Please ask for: Ms Iqraa Malik
Email: iqraa.malik@terraquest.co.uk
Telephone: 0121 234 1390
Our Ref: BN/122/21/HH
Your Ref:
Date: 23rd September 2021

Application for Planning Permission for Works or Extension to a Dwelling

Development: Erection of single storey rear and front porch extension
Location: 44 Spinney Walk Barnham PO22 0HT

Proposed Ground Floor Plan

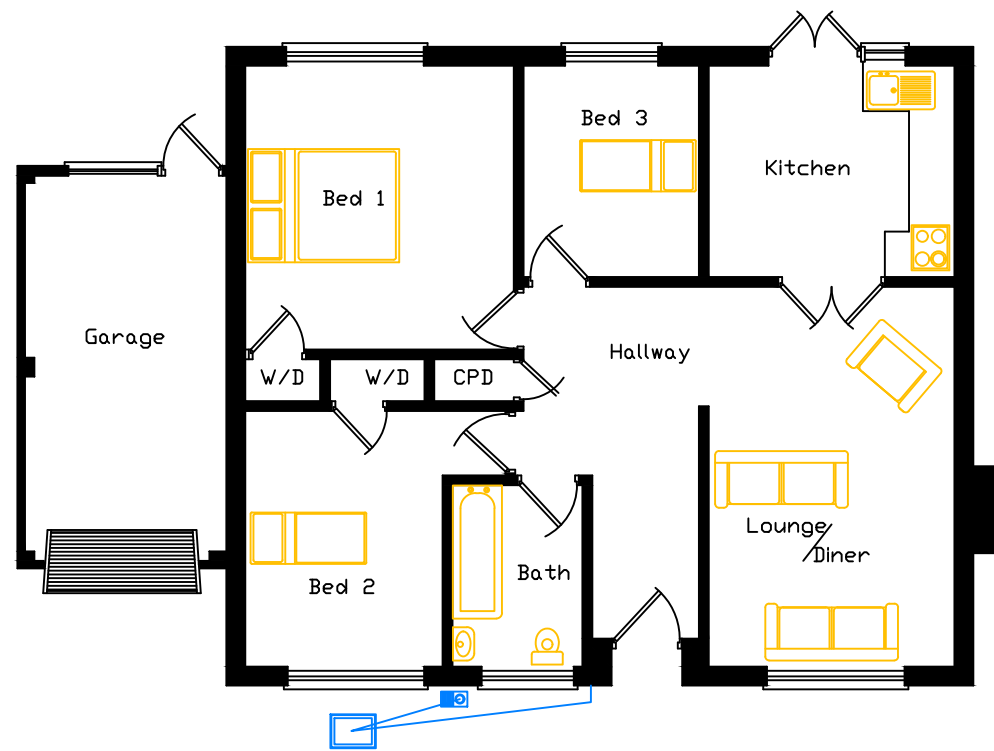
The proposed ground floor plan is inconsistent with the proposed east elevation as there should be a building line to illustrate the extension. Please review and amend.

Block Plan shows area bounded by: 496008.99, 104889.02 496098.99, 104979.02 (at a scale of 1:500), OSGridRef: SU9605 493. The representation of a road, track or path is no evidence of a right of way. The representation of features as lines is no evidence of a property boundary.

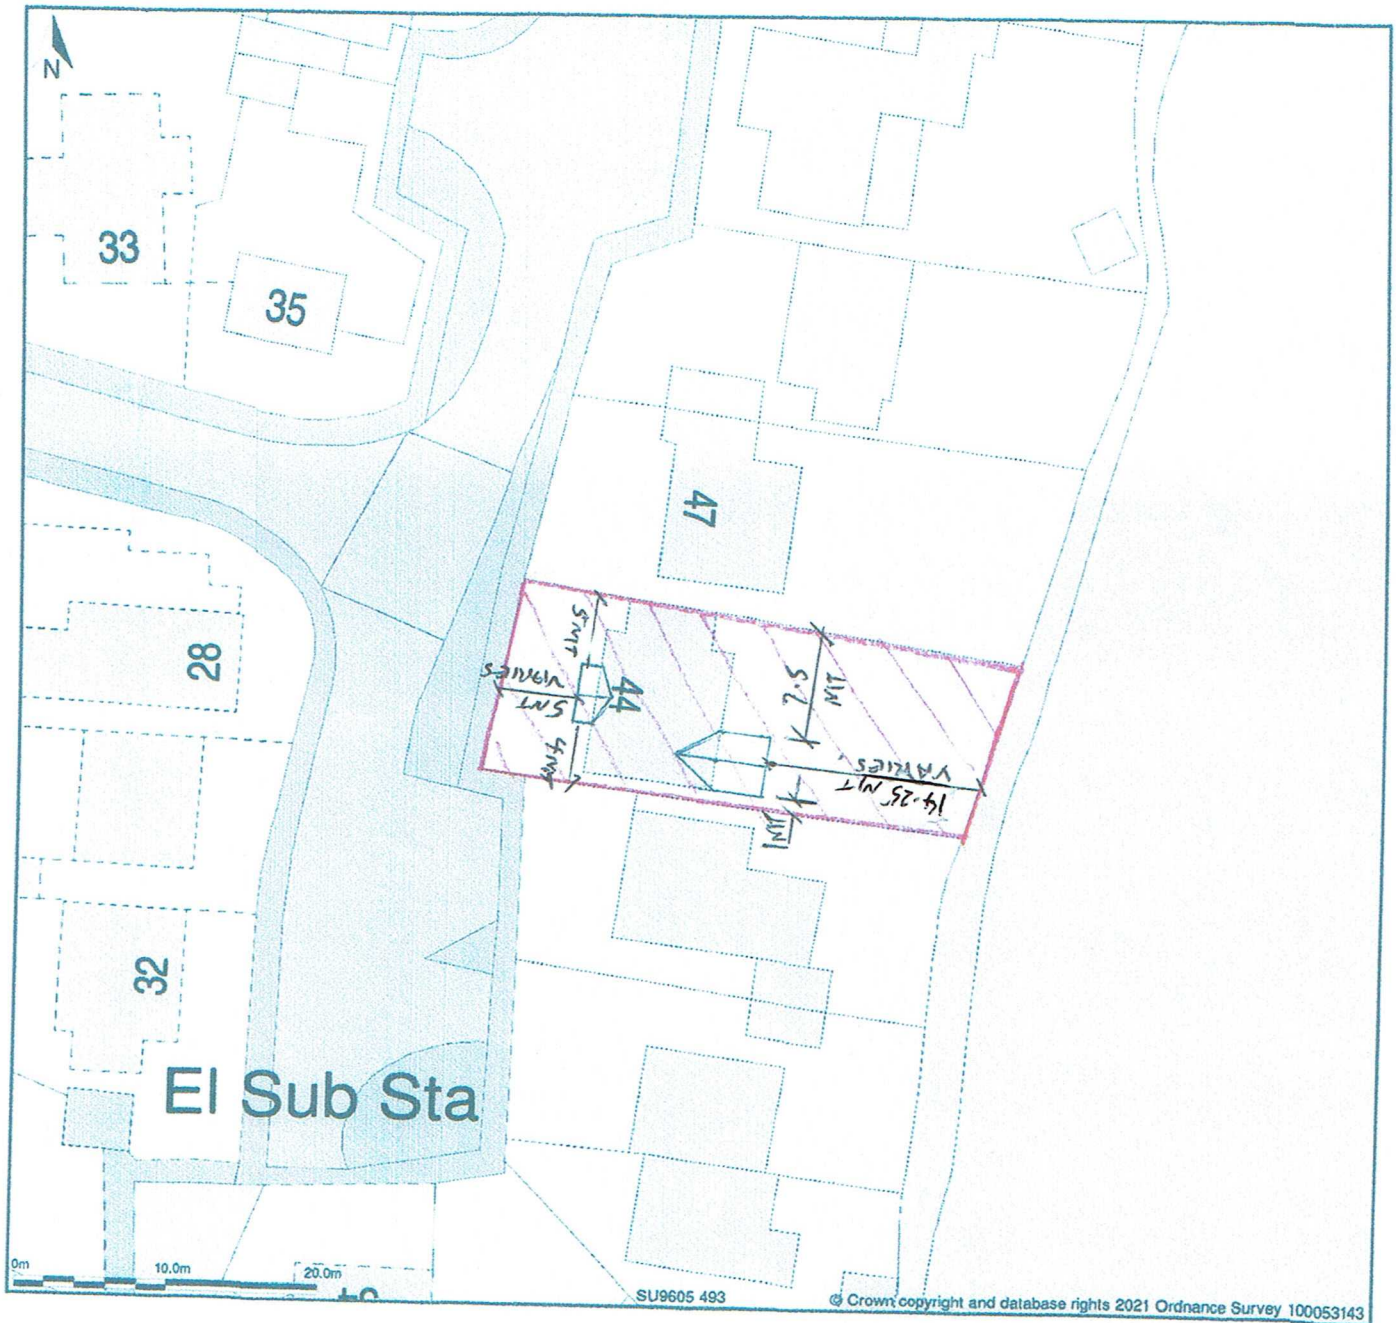
You are required to have dimensions from the proposed extension(s) to all site boundaries. Please amend.
